Comment on pg. 6 - Is this intended for living space or as a garage? Please clarify and discuss with Crystal Park HOA if this is proposed to be used for living area. Additional permitting may be required for living space in a detached structure.

Pete Youngwerth
Proposed Garage
6040 Heather Lane
Colorado Springs, CO 80829

**Floor Plan**

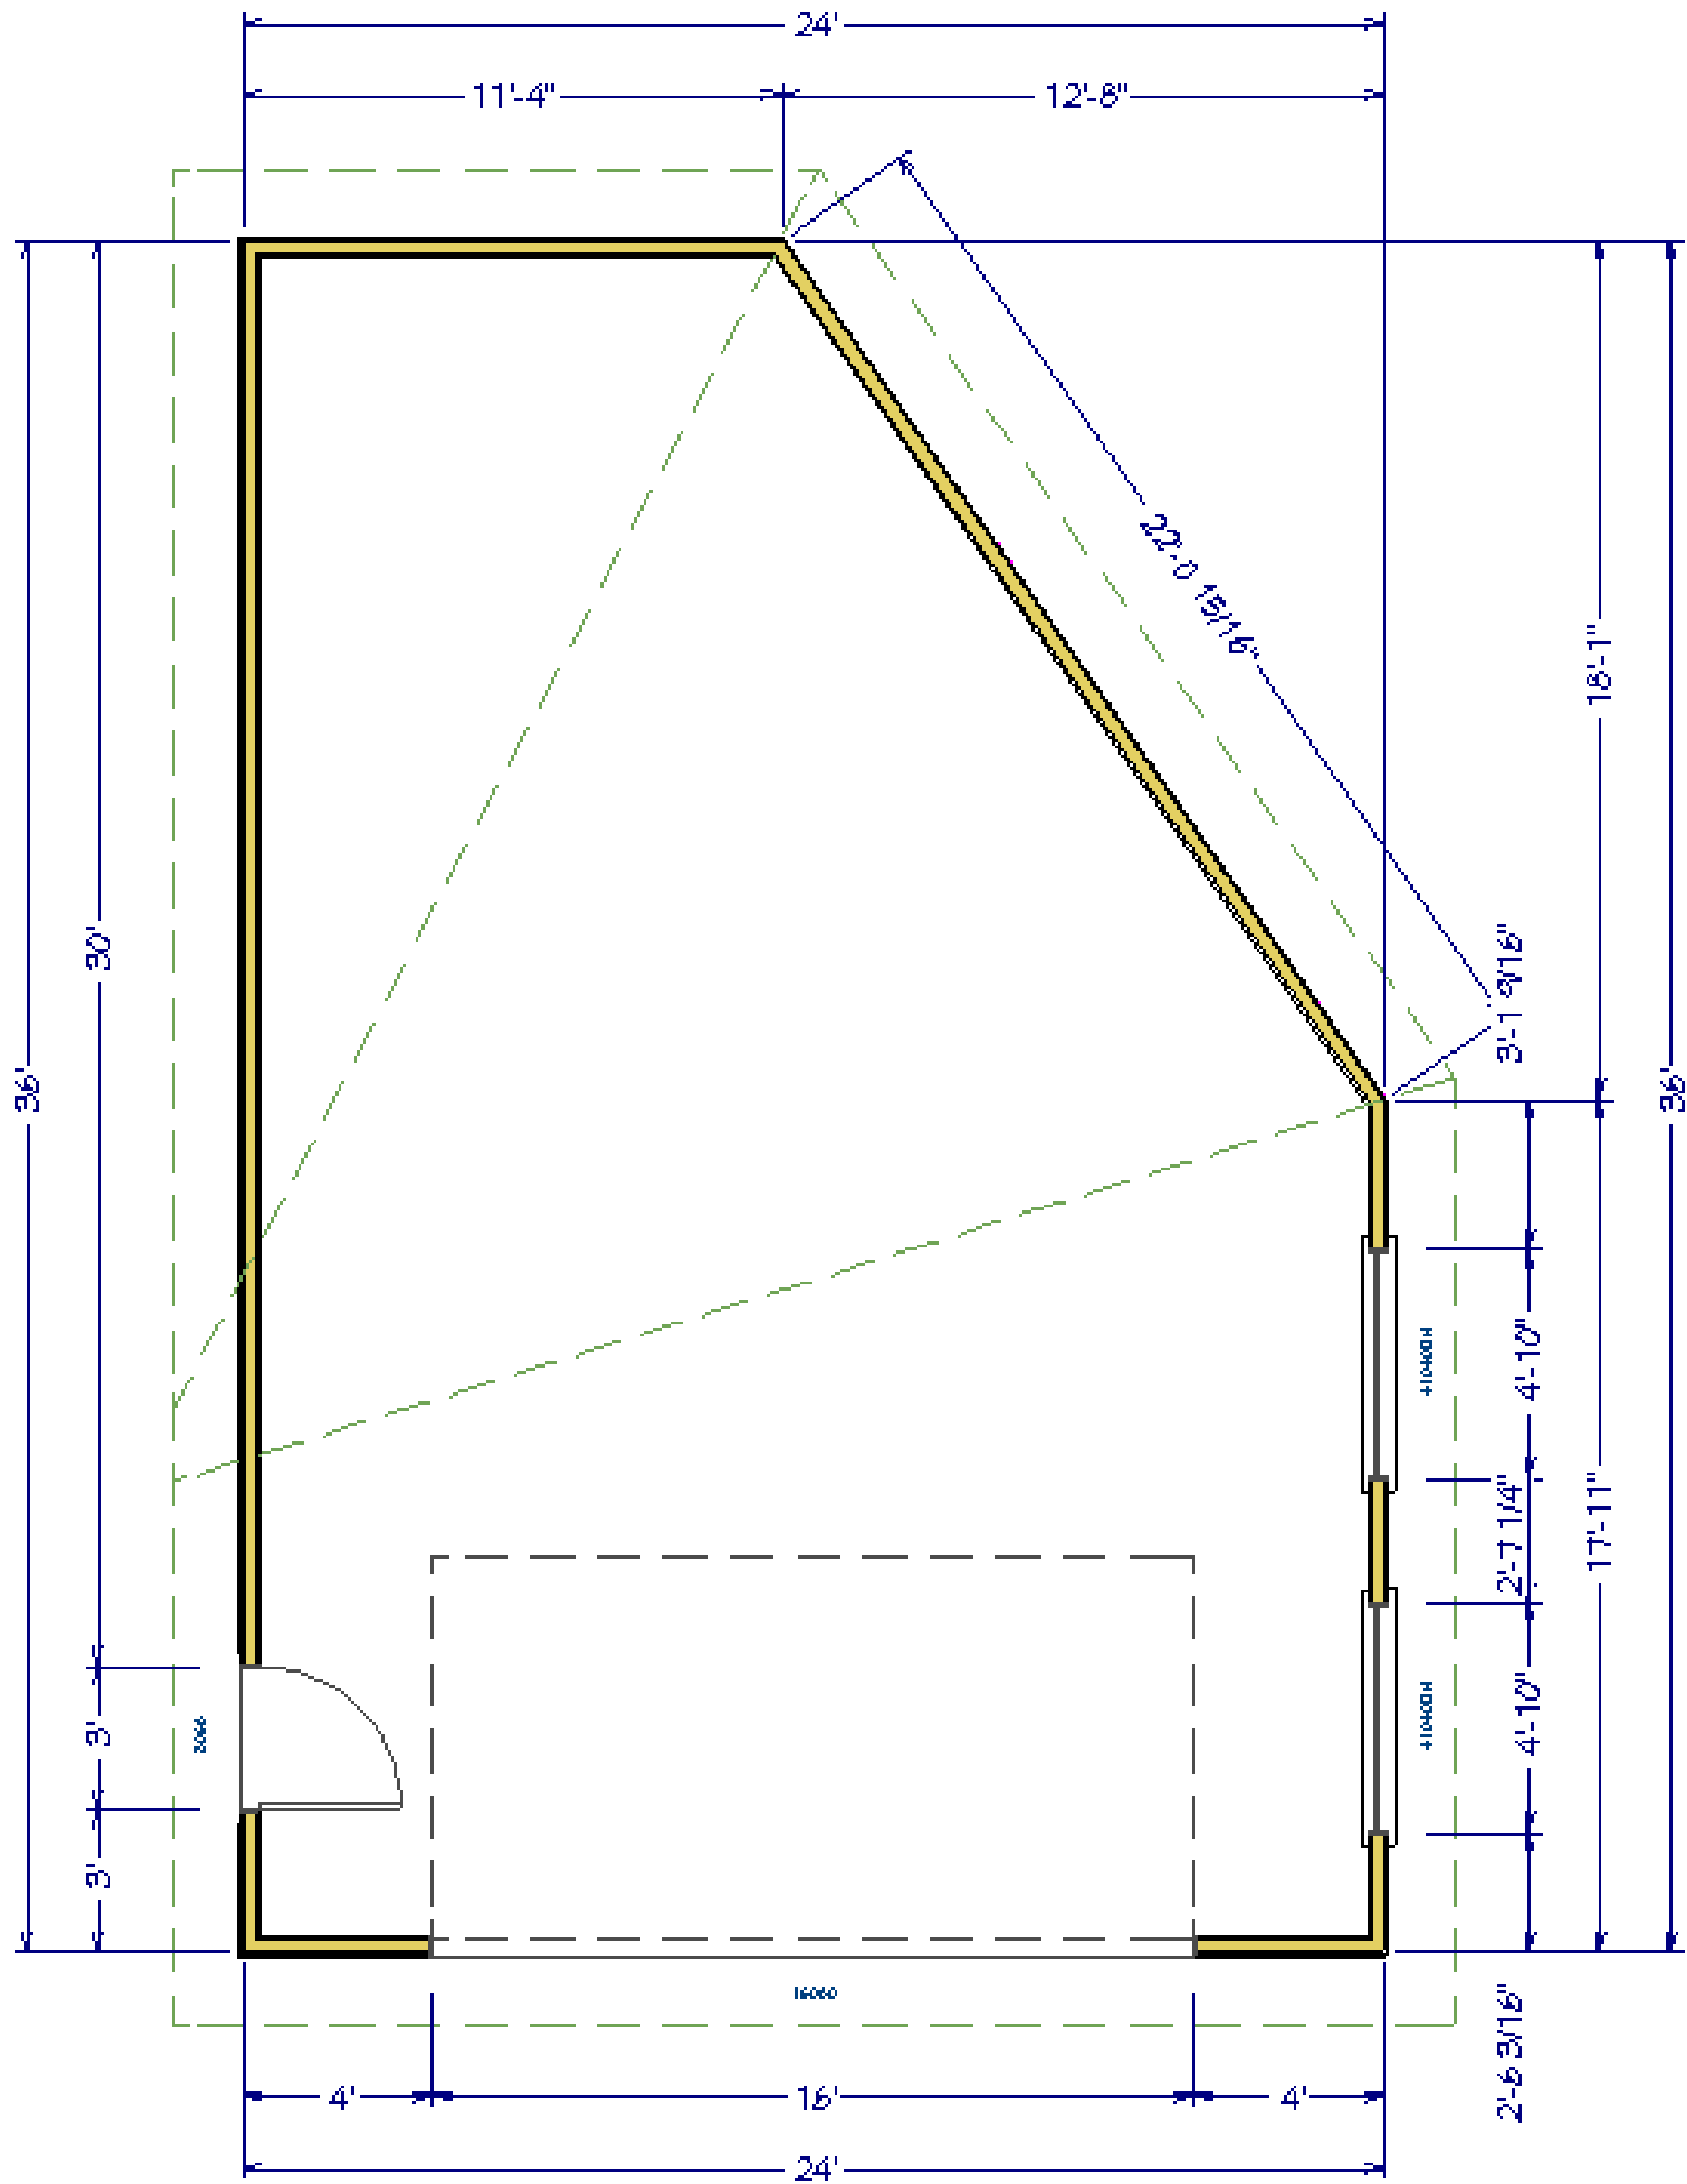
Is this intended for living space or as a garage? Please clarify and discuss with Crystal Park HOA if this is proposed to be used for living area.
